From: Elizabeth Lawrence [REDACTED]
Sent: 06 August 2021 16:12
To: Simon Davis; Planning
Subject: Fw: Planning Consultation on: AL/75/21/PL
Attachments: D1922 Consultant Response to ADC Comments 04-06-2021.pdf

Subject: RE: Planning Consultation on: AL/75/21/PL

Engineers Comments Regarding Surface Water Drainage

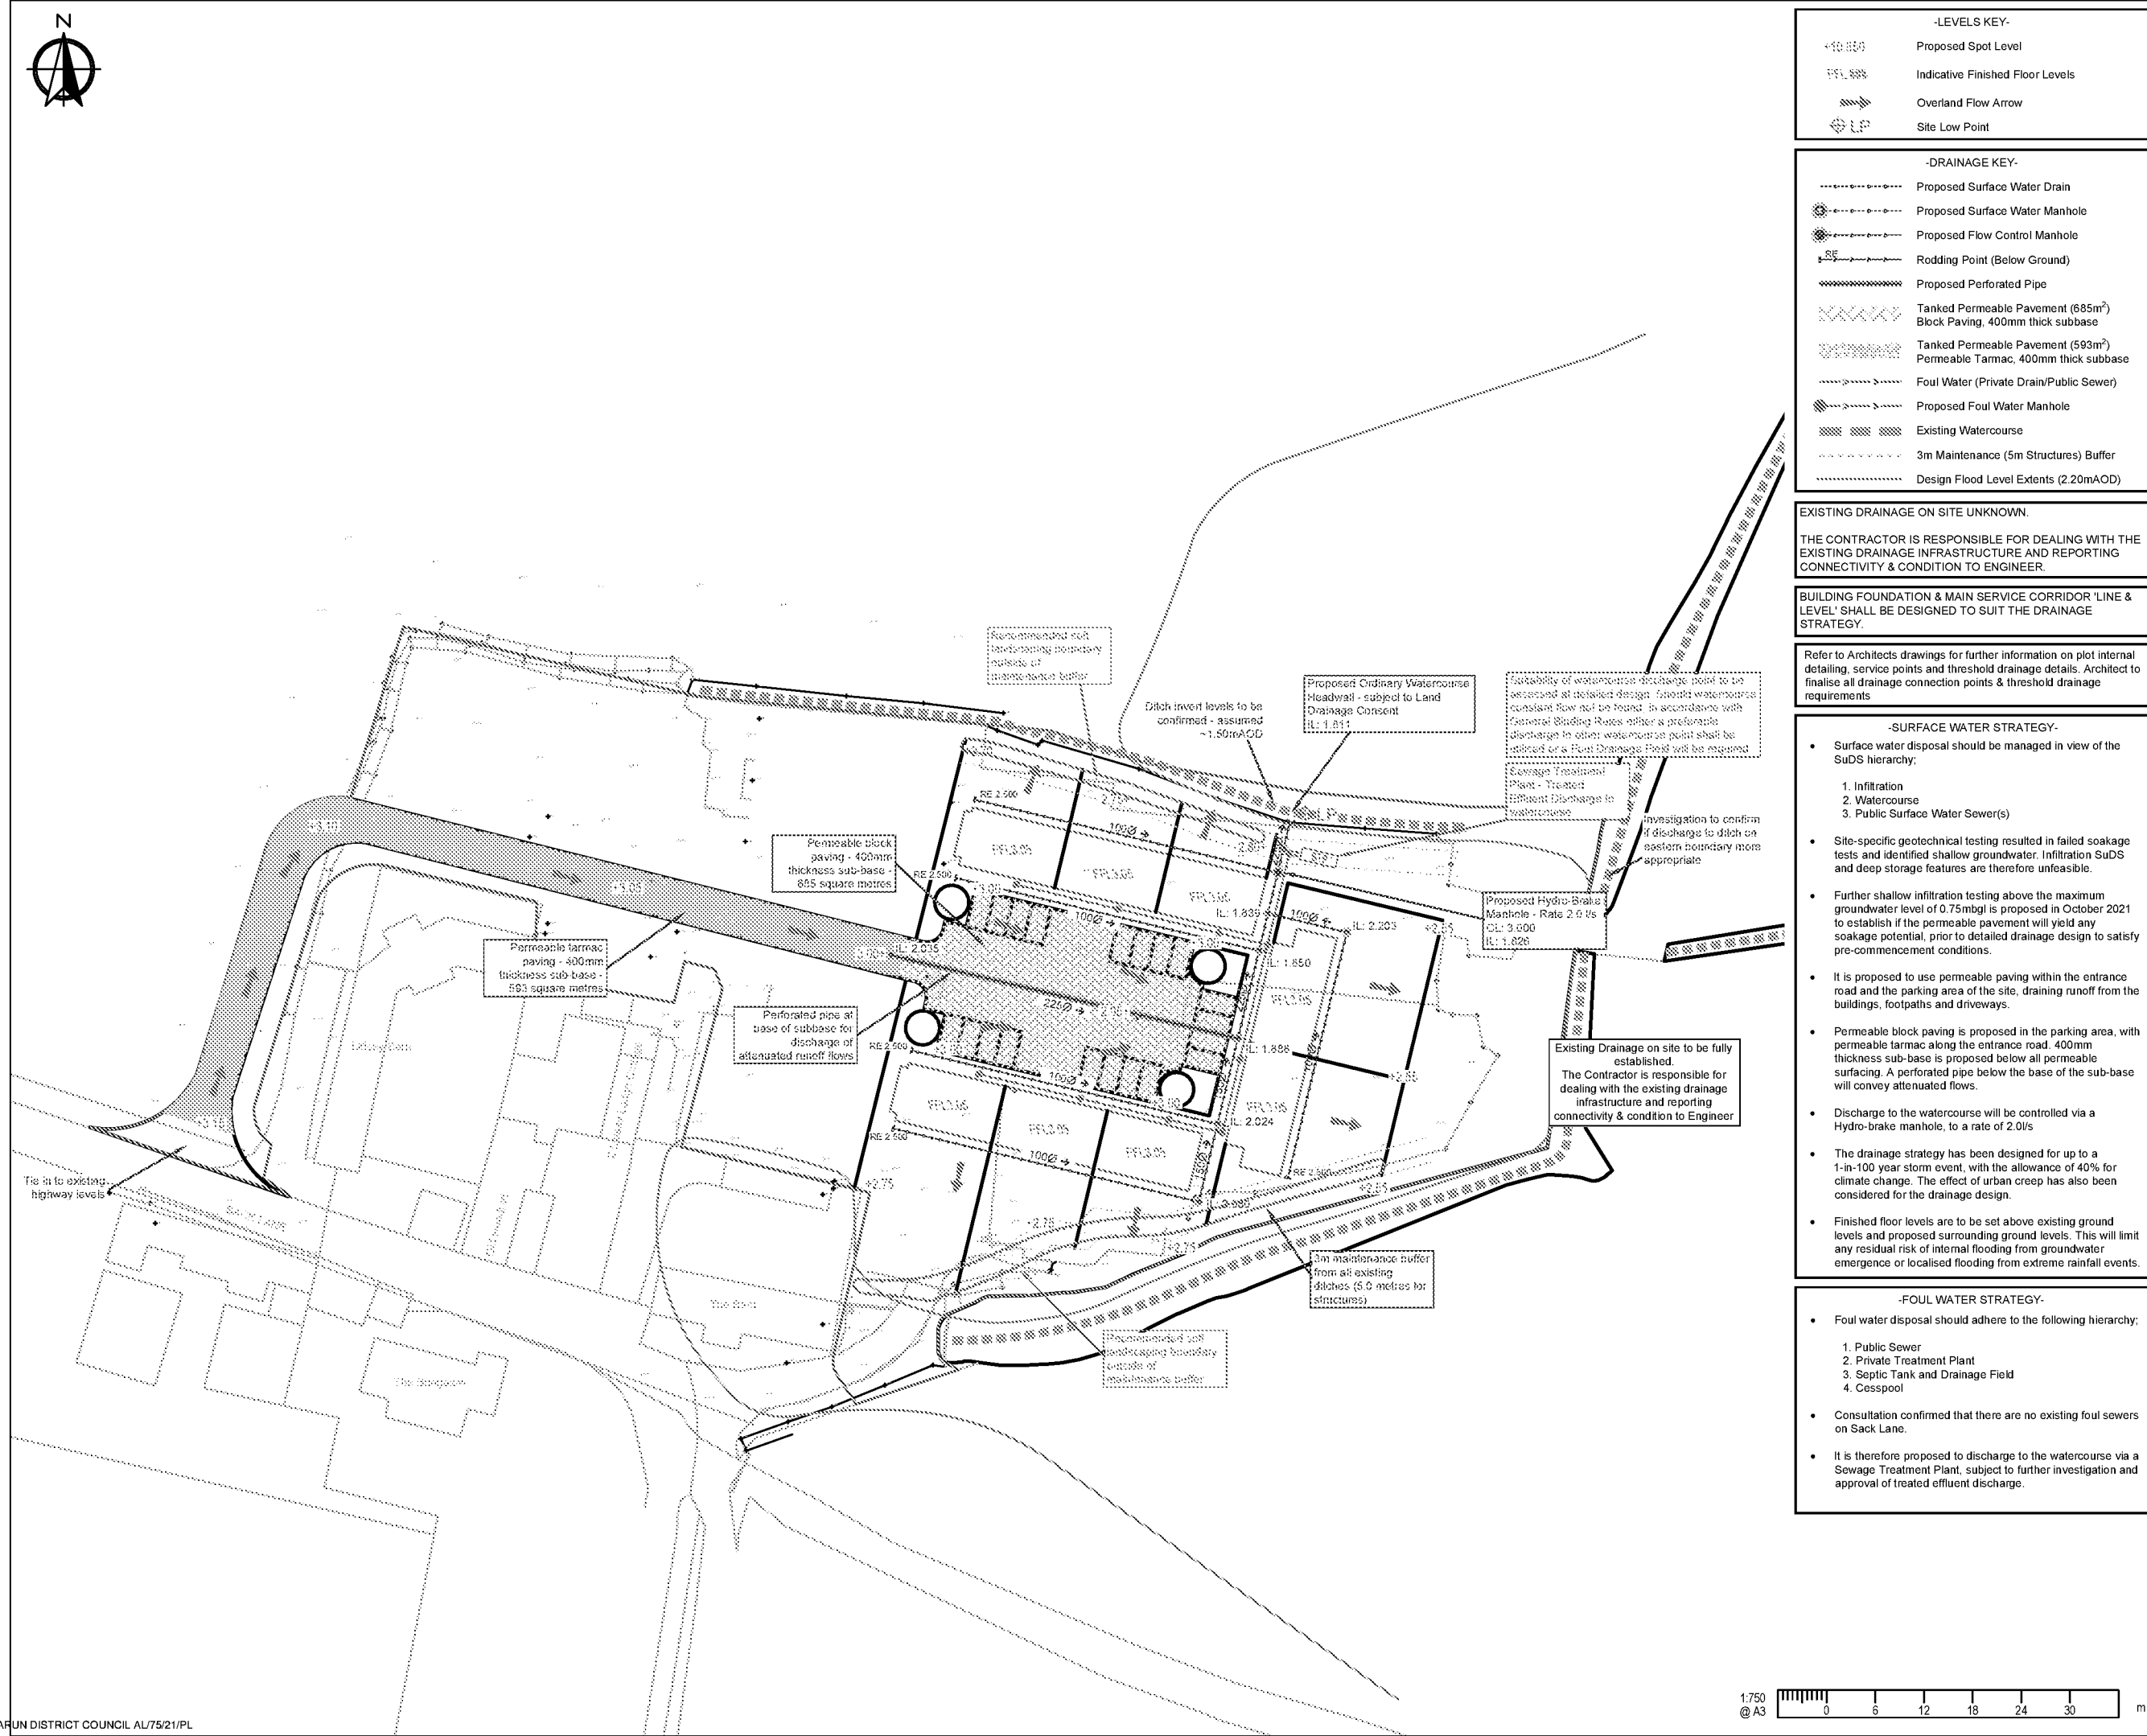
Assuming that infiltration is found to not be viable on the site, then the applicant proposes to dispose of surface water via permeable paving which provides water treatment and storage before discharging at a restricted rate of 2l/s to the watercourse at the north of the site. We are agreeable to this solution, as groundwater did not peak above 0.75mbgl we would like to see the permeable paving lined with a permeable liner to make use of whatever limited infiltration potential there may be on the site.

The applicants engineers are aware of the required easements to the watercourse as these are cited within the FRA. Please ensure that not only buildings, but also boundary fences are not sited within 3m of the watercourses. Please provide a plan showing the buffers and the flood zones when a Discharge of Conditions application is made (if this application is approved).

As per our previous response (attached), winter infiltration testing at a shallow level above 0.75mbgl where the permeable pavement is proposed will need to be undertaken as part of the detailed design to discharge these conditions.
